From: [Early, Shane \(DNR\)](#)
To: [Rachael Stevie \(CD\)](#)
Cc: [Andrews, Garren \(DNR\)](#); [YOUNG, BRENDA \(DNR\)](#); [MAUNEY, MARTY \(DNR\)](#)
Subject: RE: LP-22-00002 Mohar Farm - Notice of Application
Date: Thursday, March 31, 2022 10:15:16 AM
Attachments: [image001.png](#)
[image002.png](#)

- The project area falls within the I-90 East Spotted Owl Special Emphasis Area (SOSEA), however the parcels in question are noted as having “Non-Habitat, potential for future habitat”. Since this area will become further developed, it is unlikely to ever support Northern Spotted Owl again.

PRELIMINARY MOHAR FARM CLUSTER PLAT

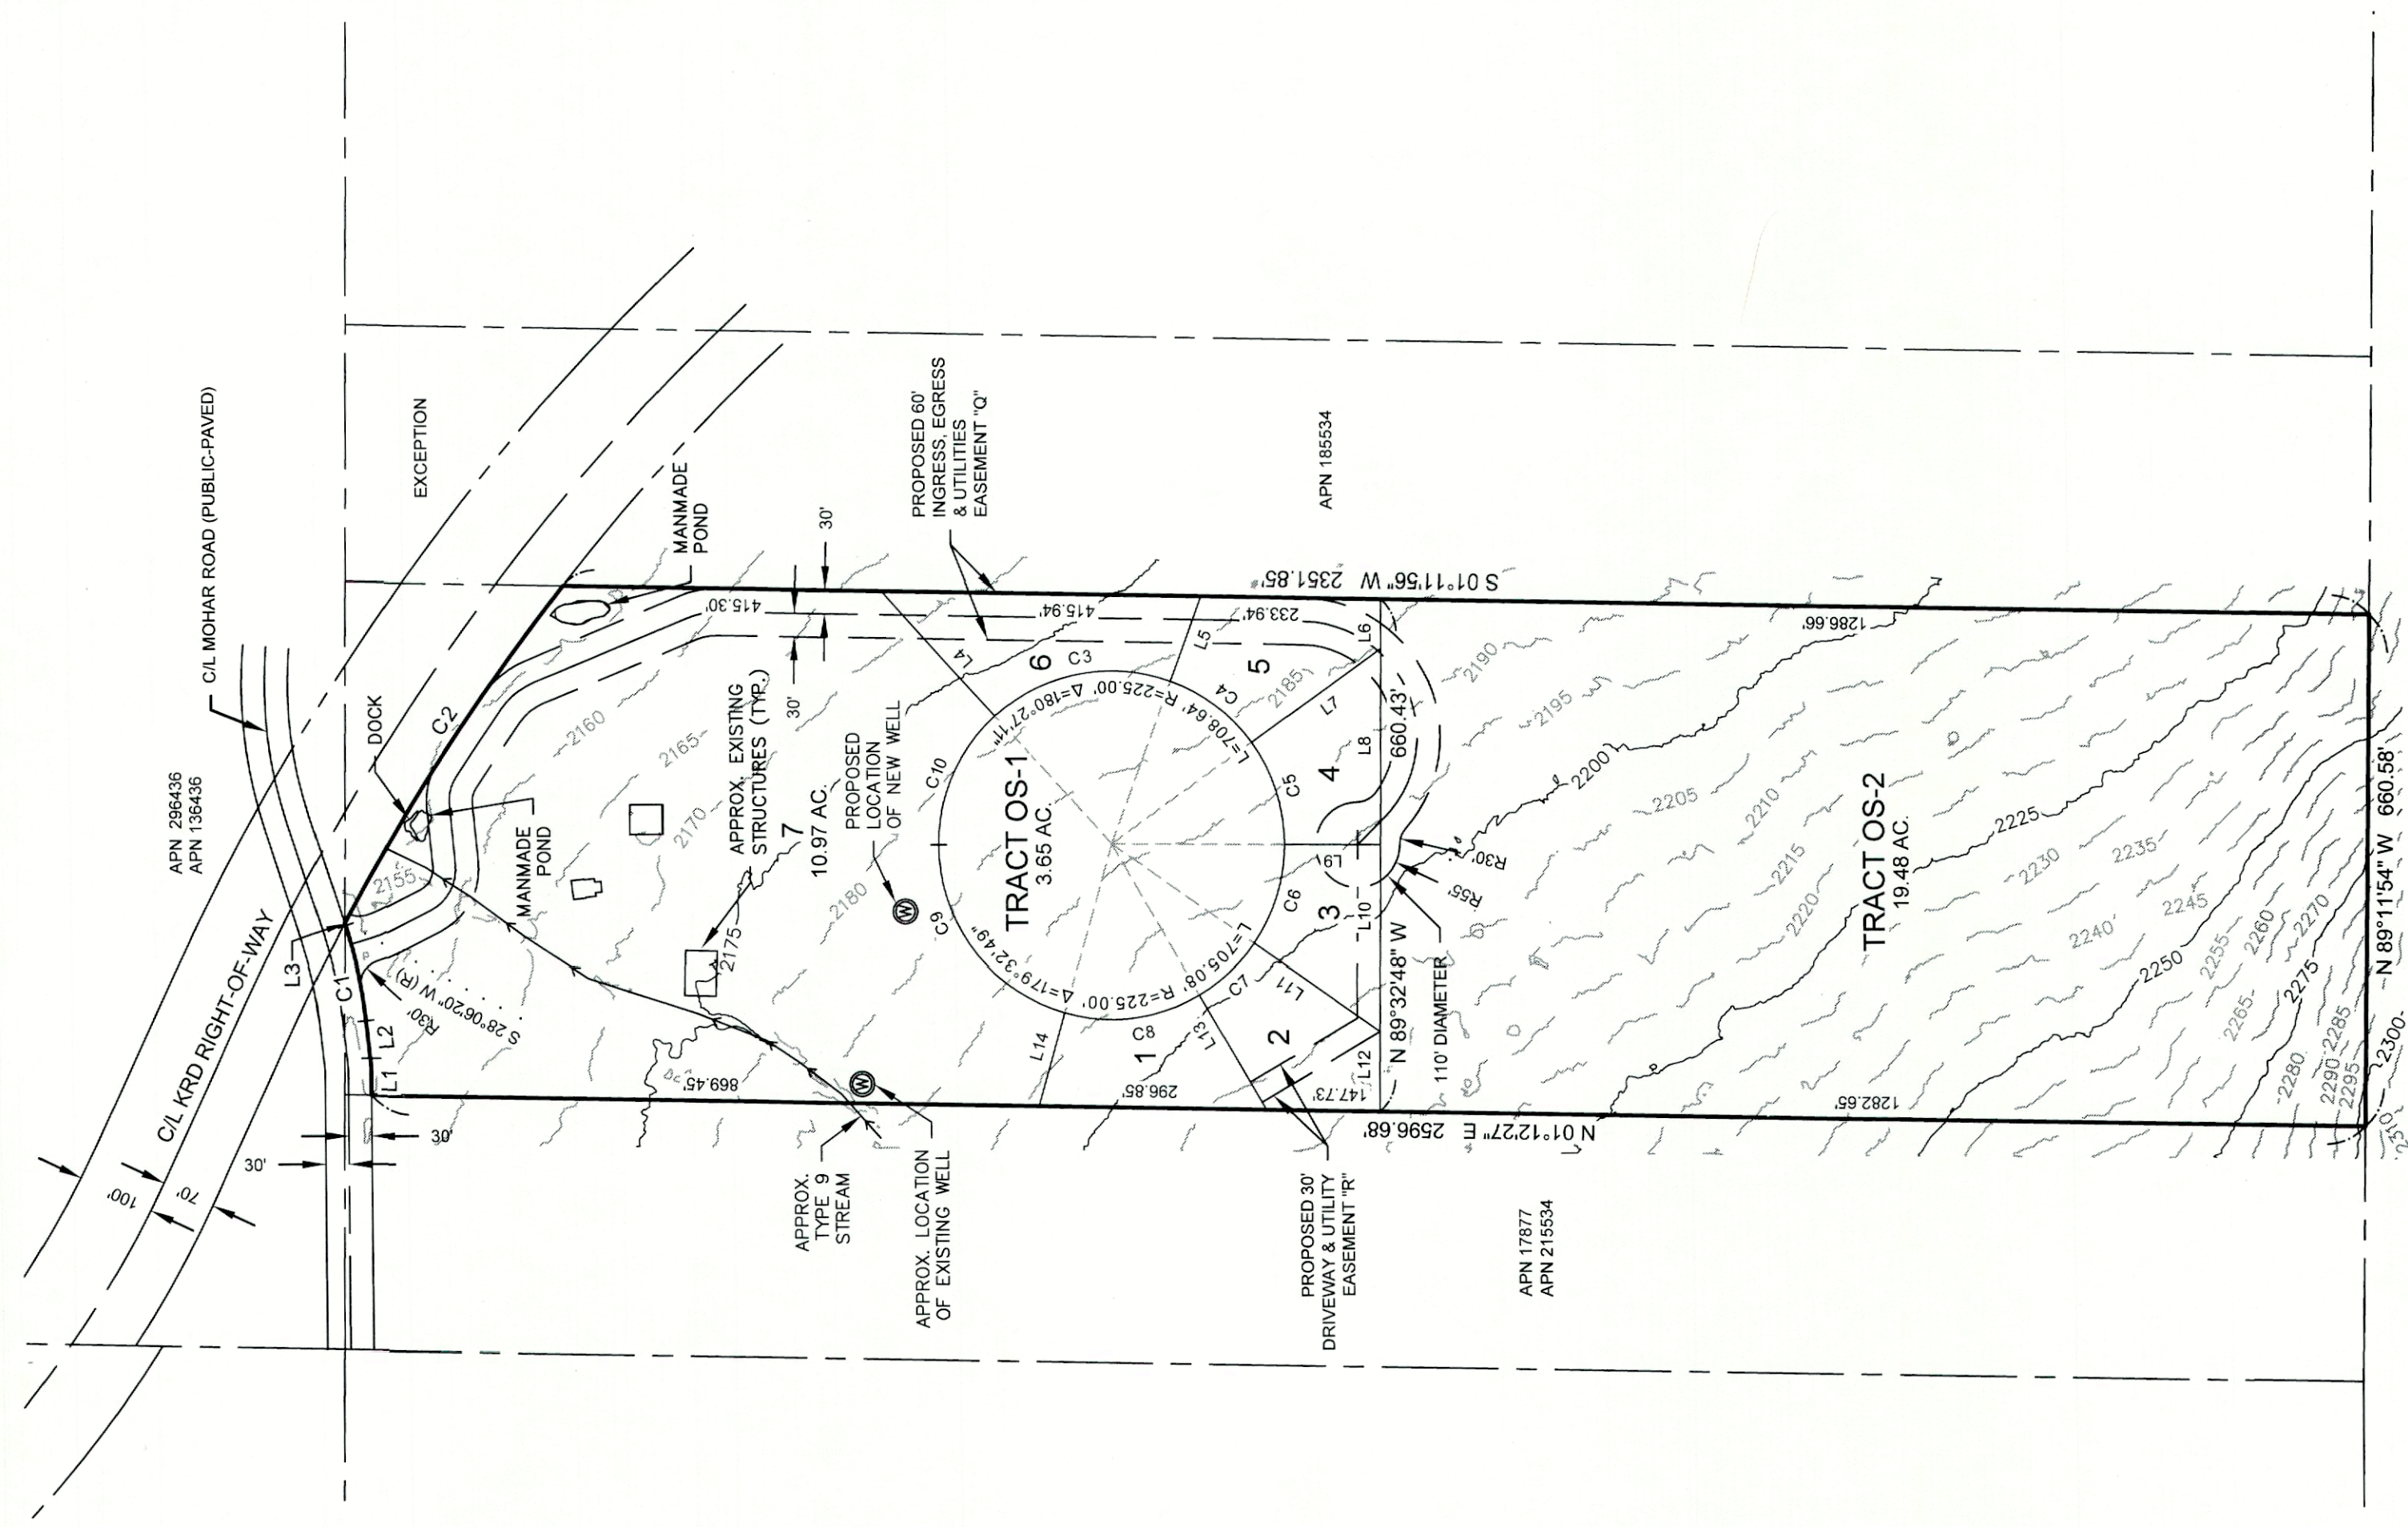
- Future landowners of the proposed lots to be created may be subject to needing an approved Forest Practices Application (FPA), if they own more than 2 contiguous acres and plan to convert a portion of their property to non-forestry (i.e. to build a residence, shop, etc.).

- It appears that the northern half of this project area is already devoid of any forest, however the aforementioned need for a FPA is likely to apply to the southern half of the Long Plat area.

- Future landowners should contact DNR SE FP prior to development, so that a forester may conduct a field review (site assessment), as there are some existing cleared areas that could allow for building a home without conducting any forest practices (i.e. logging, stump pulling, etc.).
